Historic England

THAMES TIDEWAY TUNNEL: REF : Ref: 2530-TDWAY-TTTUN-990-ZZ-CO-700190

**The Thames Water Utilities Limited (Thames Tideway Tunnel) Order (SI:2014/2384)¹
Application for a non-material change in relation to the Victoria Embankment
Foreshore (VCTEF) and Blackfriars Bridge Foreshore (BLABF) site**

Document Information
Application for Development Consent
Extent of loss of listed river wall
Sheet 2 of 2
Book of plans - section 19
DCO-PP-17X-BLABF-190023
January 2013

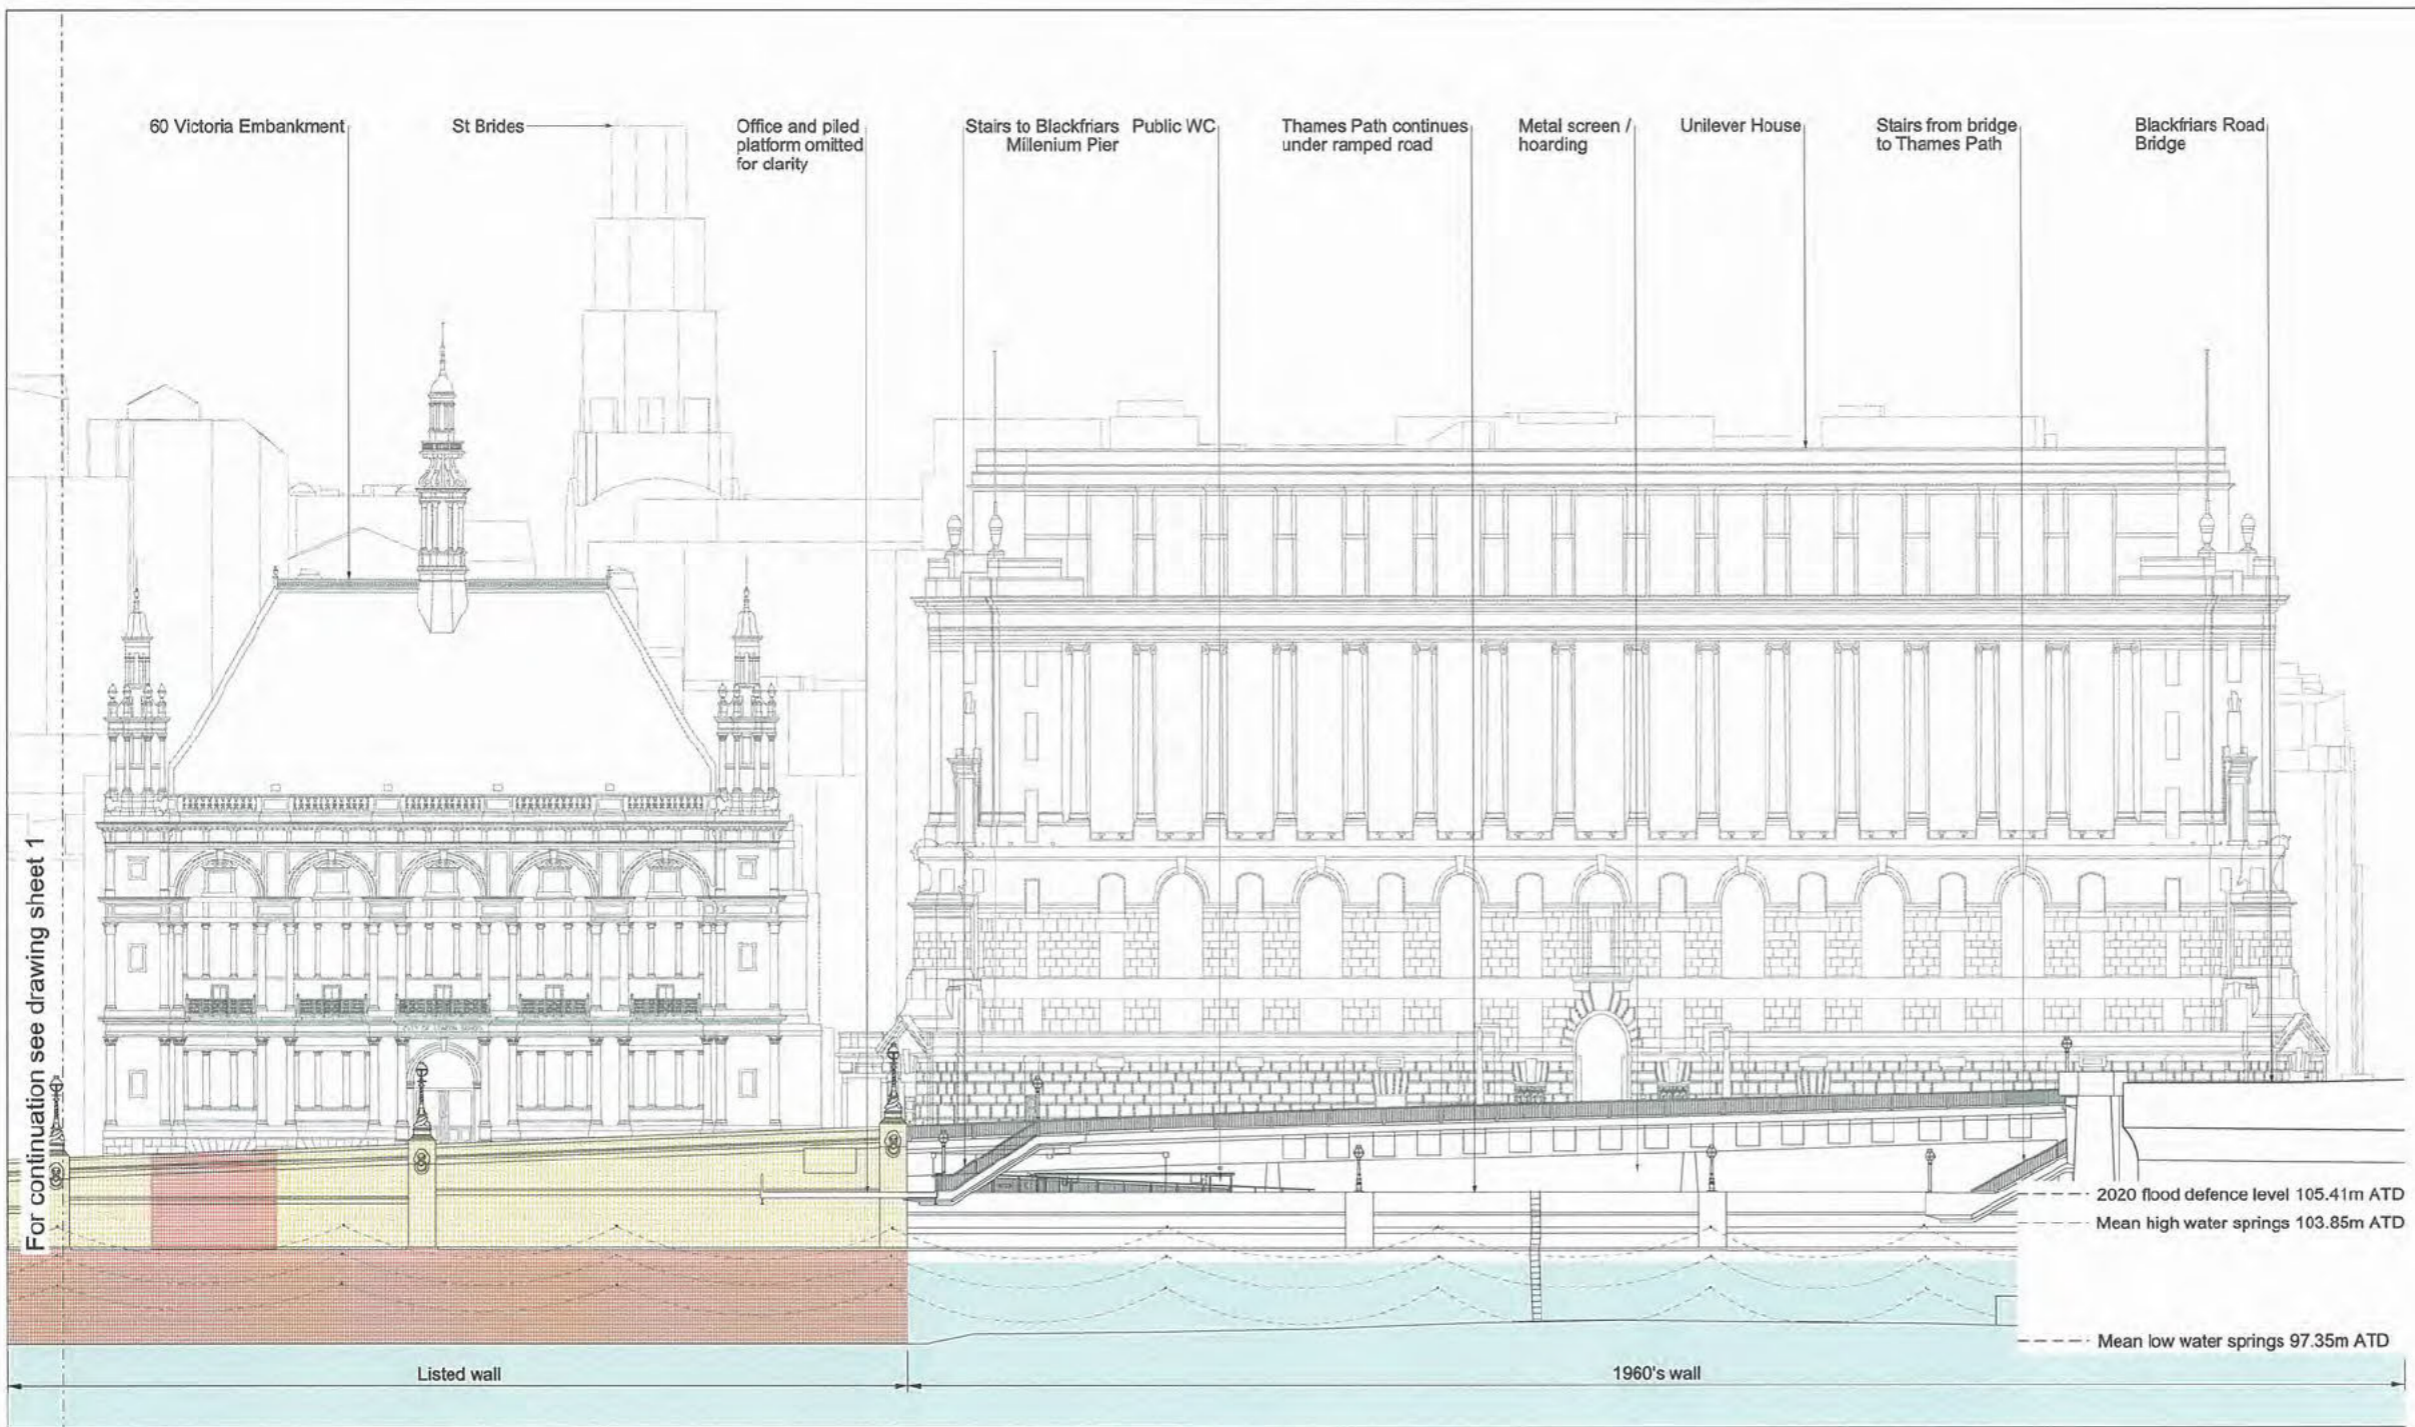
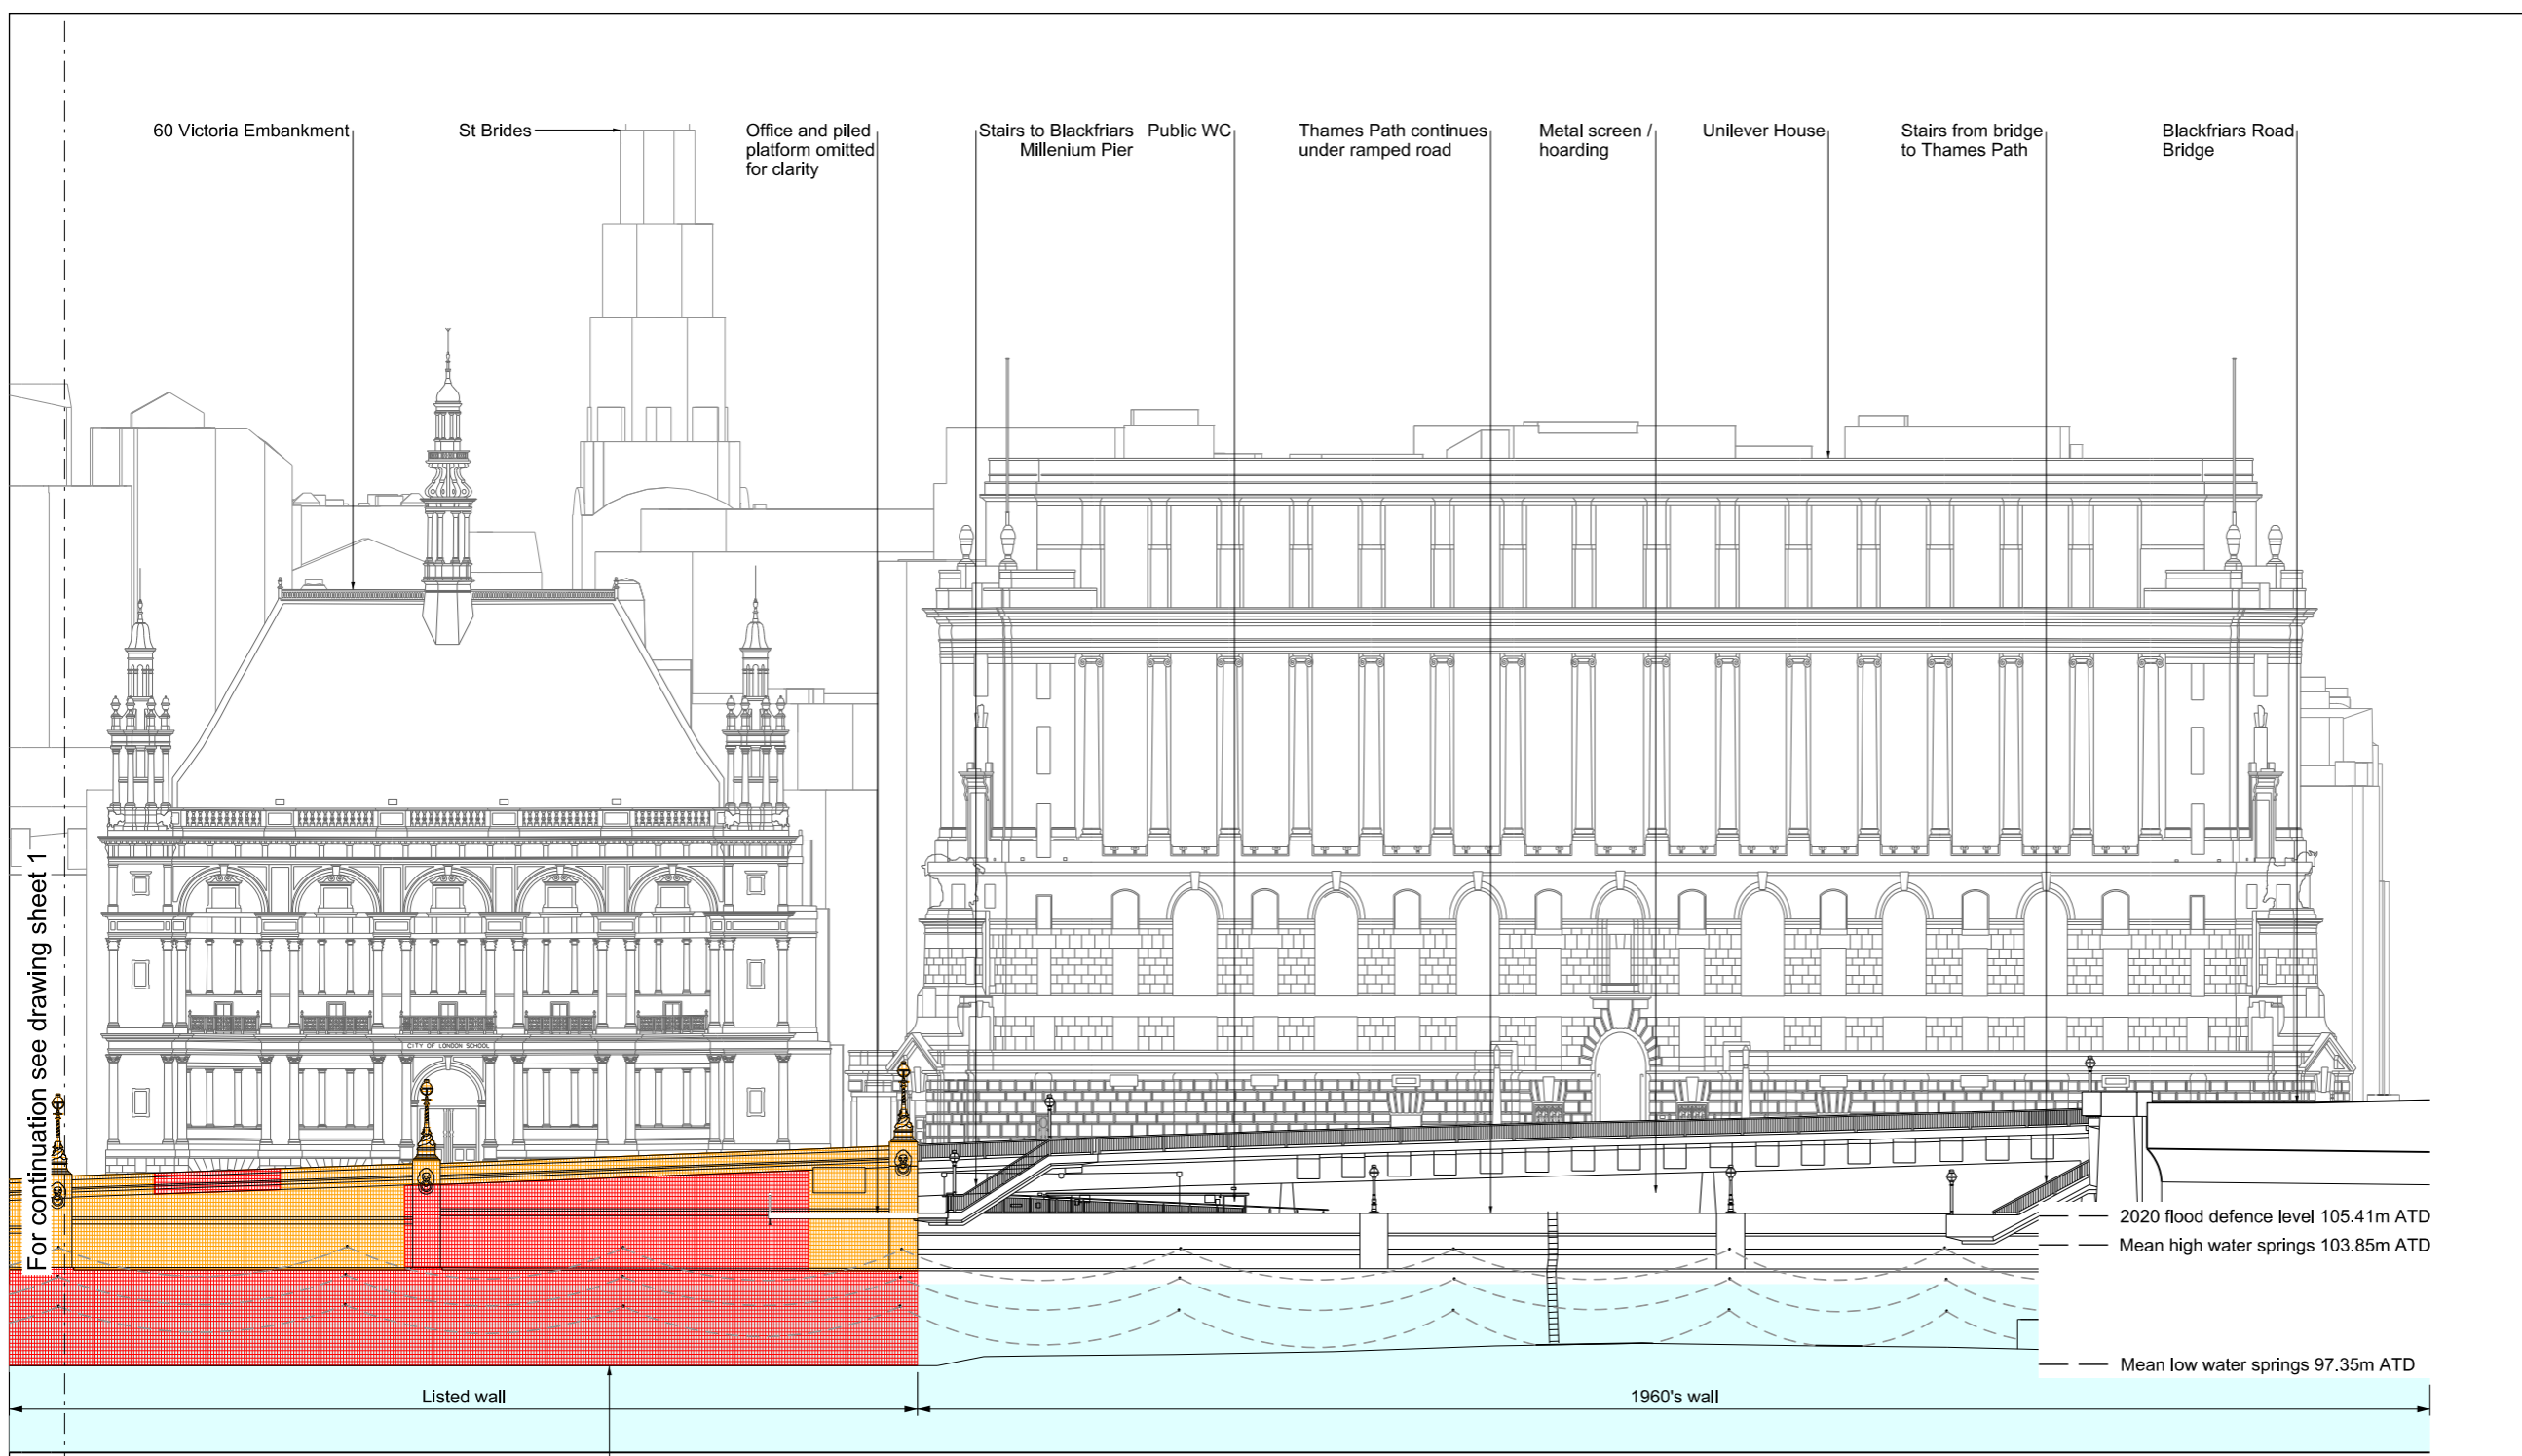
At BLABF there is increased harm in respect of the increased loss of historic fabric (80m sq) through greater removal of the listed river wall. However the loss to some extent is mitigated through the location being permanently obscured by the new foreshore structure when constructed. On balance we would consider that the requirements resulting from redevelopment of the pipe subway provide justification for the revised scope and that the harm to heritage assets remains less than substantial as defined within the National Planning Policy Framework. While we would not consider that substantial harm equates to complete removal of the heritage asset as implied with the applicants accompanying statement (2530-TDWAY-TTTUN-990-ZZ-RG-704430 para. 4.2.5) we do in this instance agree with the applicants conclusion and we are content that the proposed non-material amendment is justified in heritage terms.
